EAST ANGLIA ONE NORTH

EAST ANGLIA TWO

Issue Specific Hearings 3 (ISHs3)

Post-hearing submission: written and photographic

East Anglia ONE North and East Anglia TWO
Hundred River and Statutory Designated Sites Location

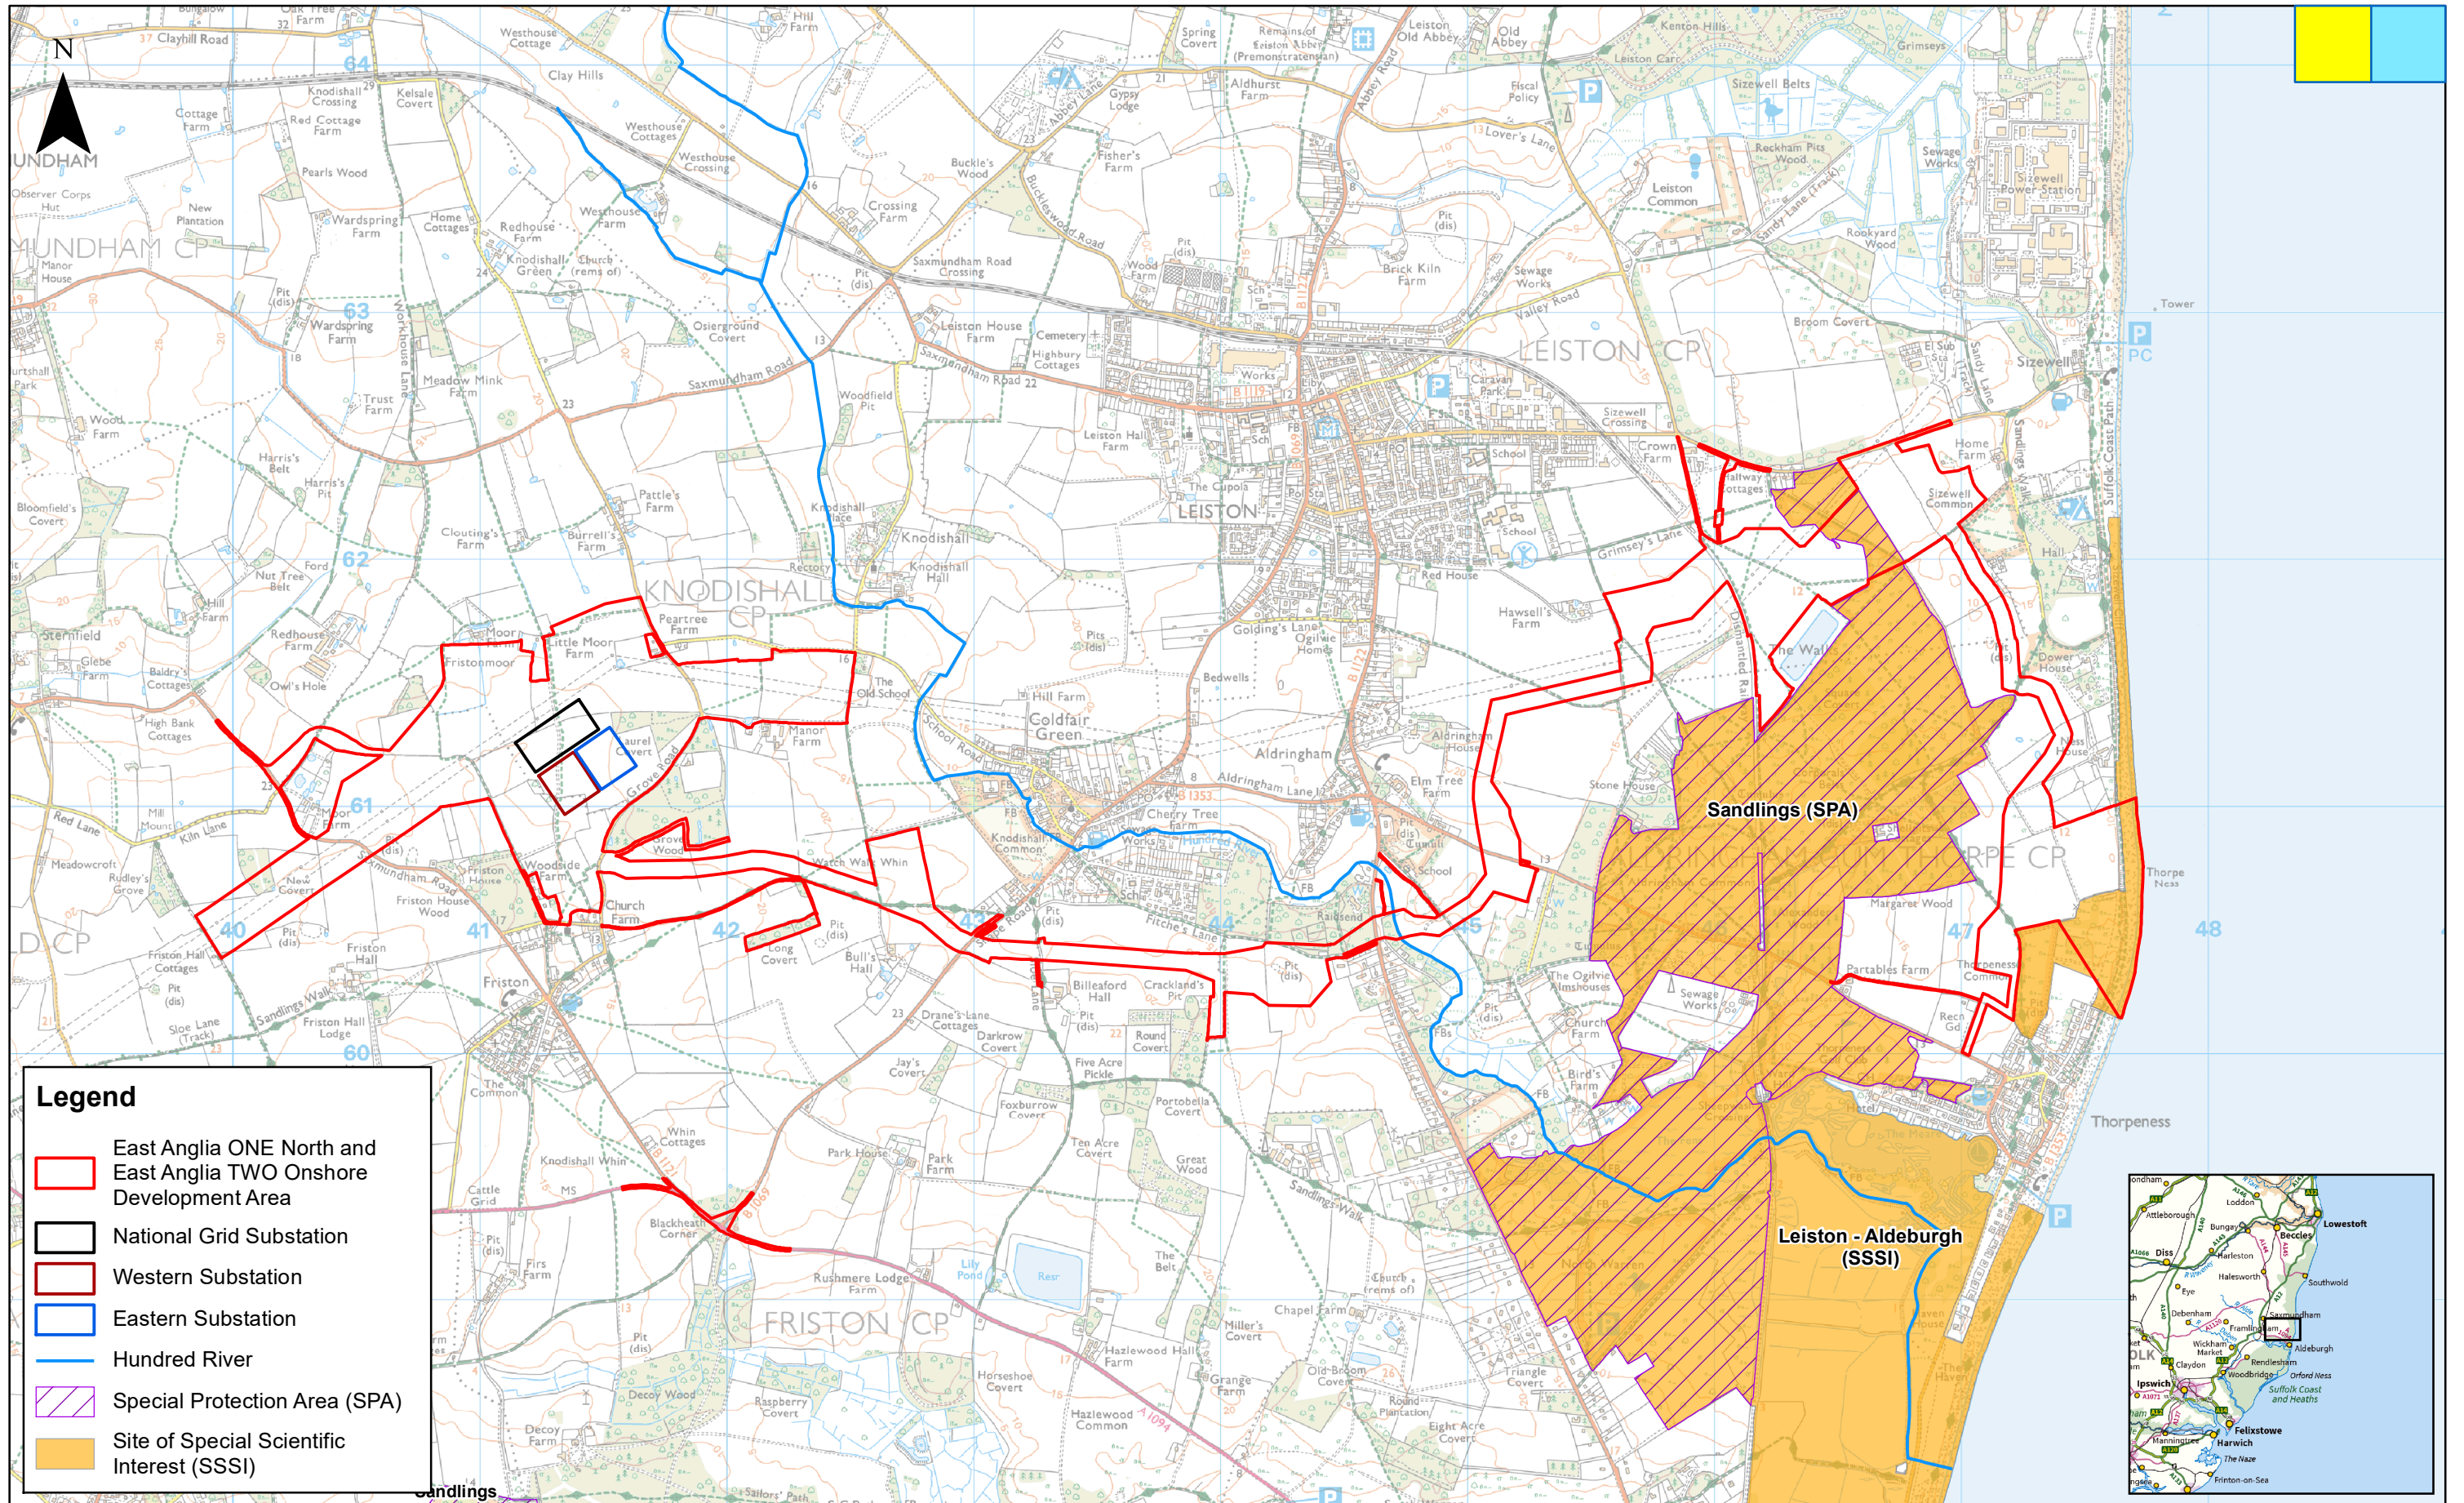
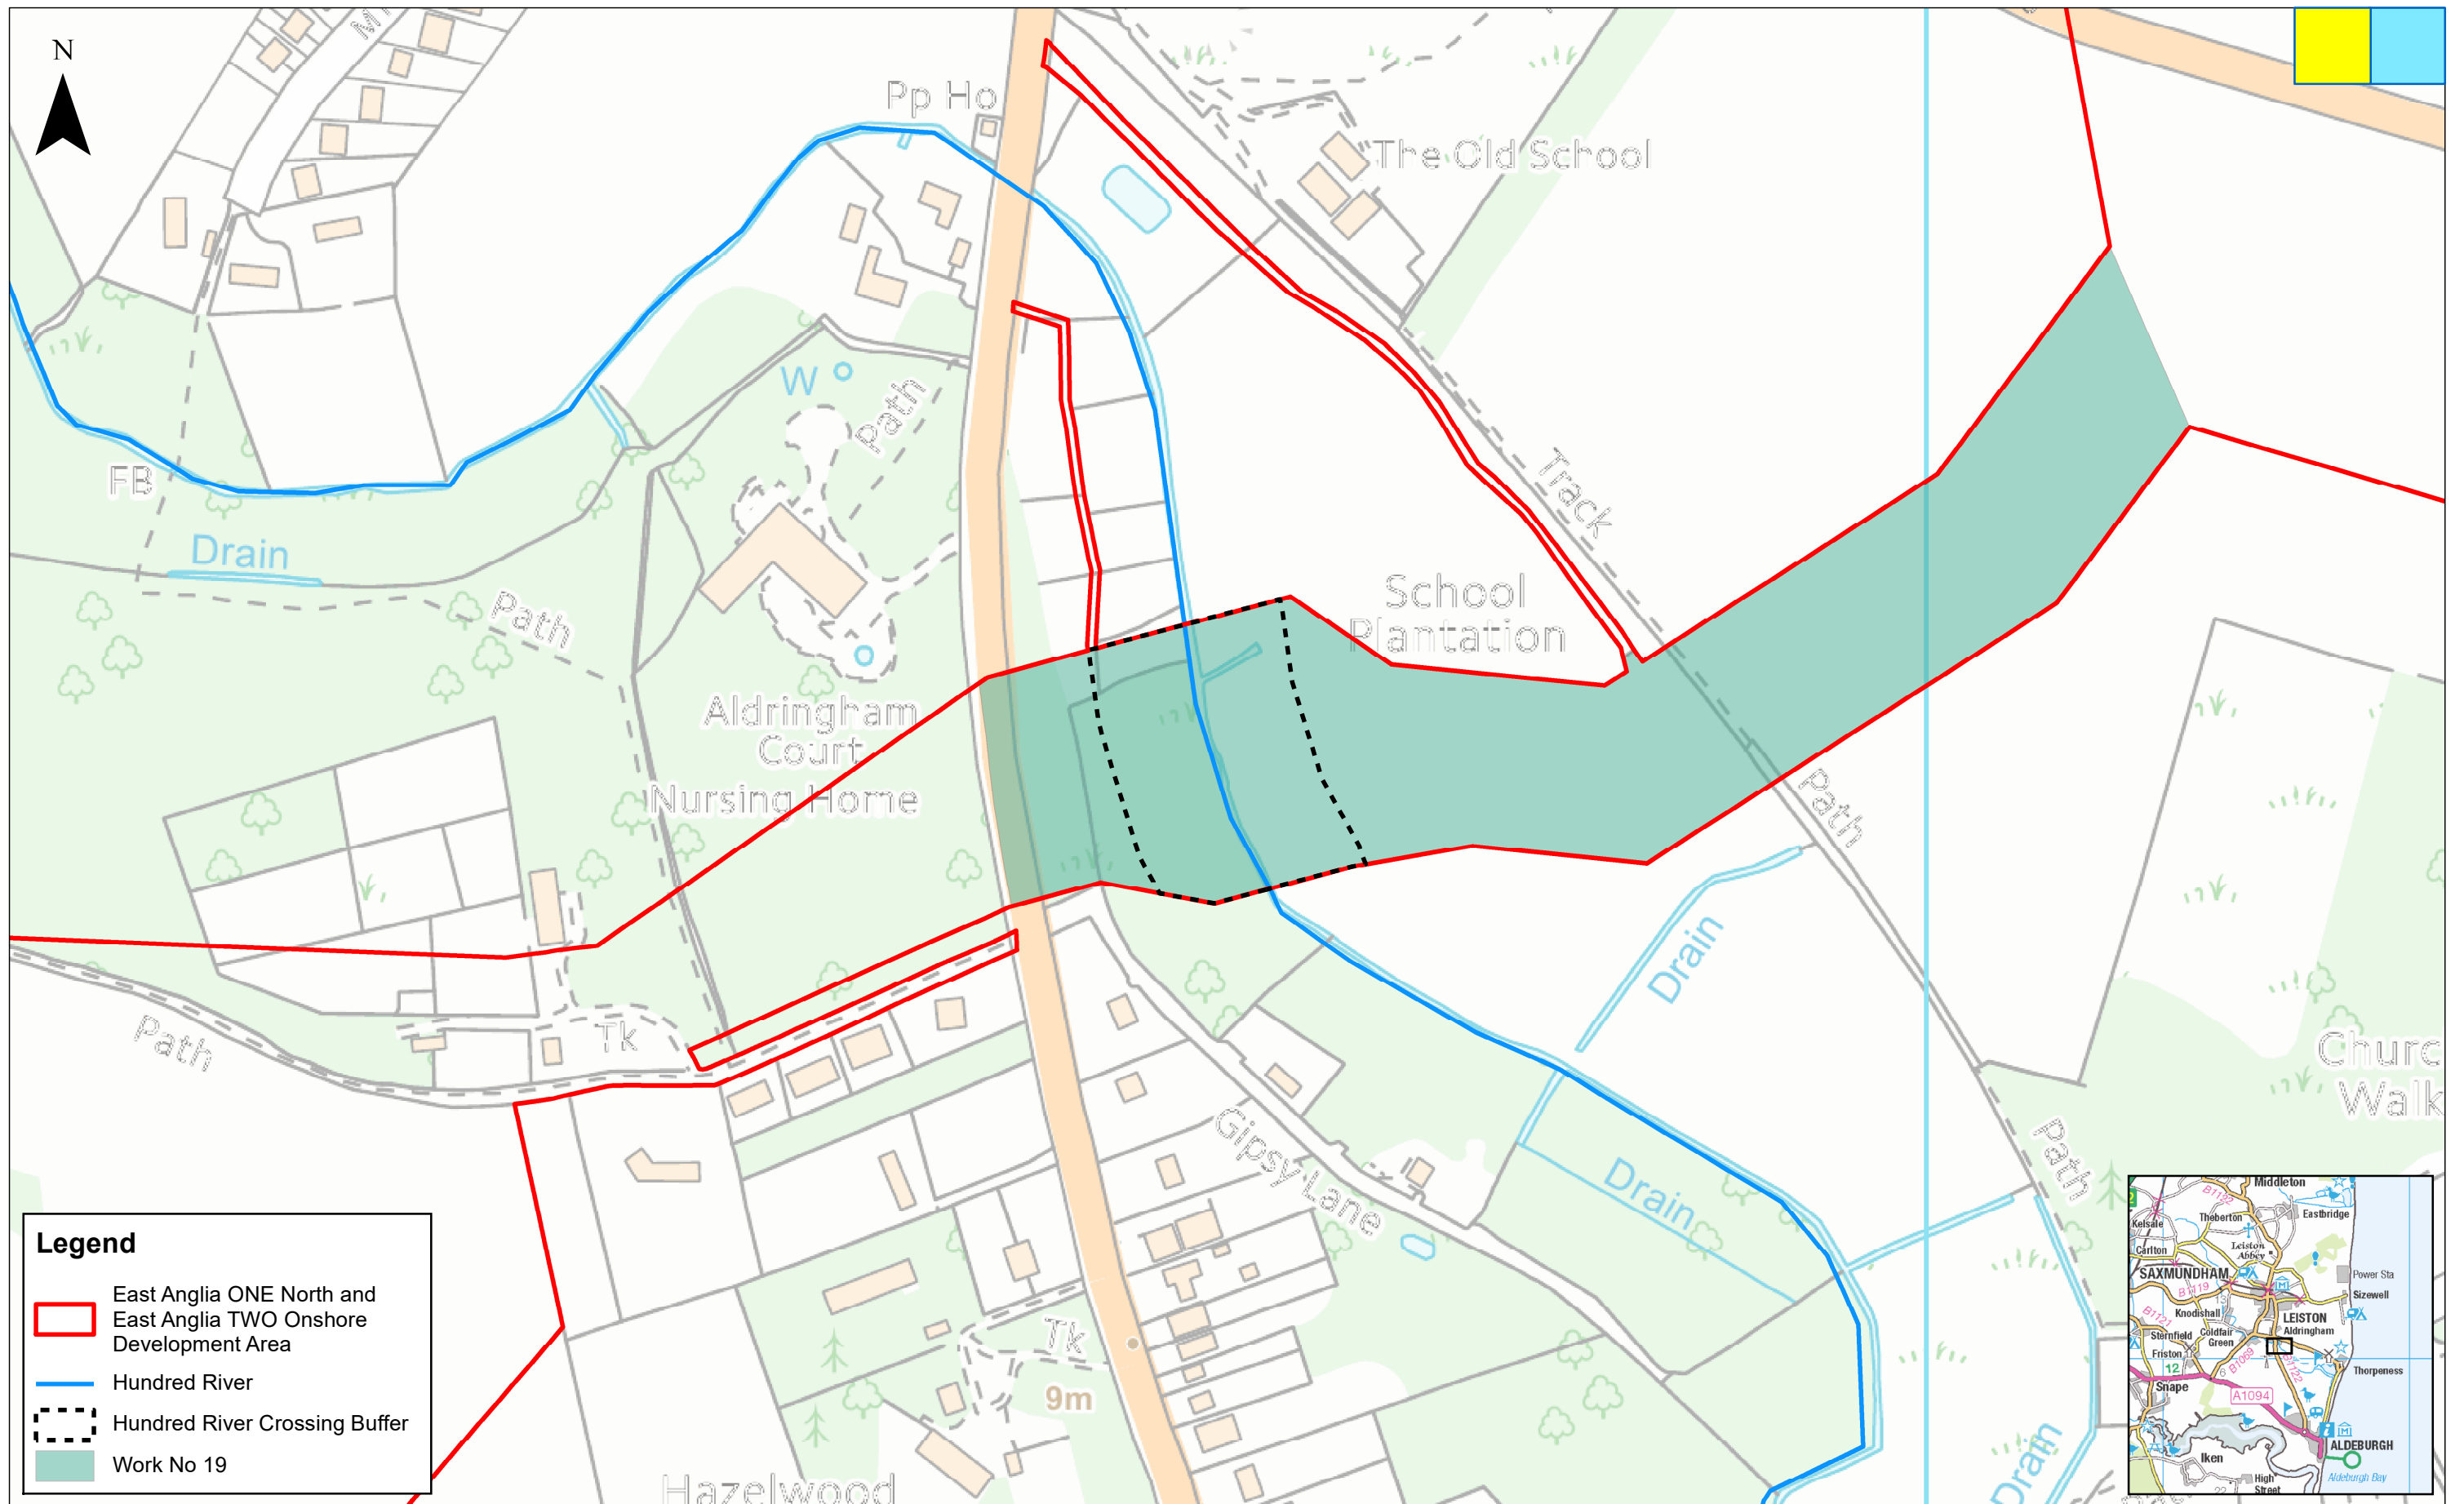
6.1 The River Hundred has not been surveyed adequately so the impacts on the river as medium and habitat are not properly addressed.

6.3 The Applicant did perform some Otter and Water Vole surveys after initially dismissing their presence, but the omission means that baseline information necessary for the decision on the river crossing is still not complete. There is scant information about vegetation, invertebrate, amphibian, bird or crustacean in the survey, neither in, nor by, the river.

6.5 Natural England remind us that the river is directly, immediately and intimately connected to the Sandlings SPA and SSSI. The river should be properly assessed as a receptor before any decision can be made on crossing the river. Direct and indirect impacts should be considered.
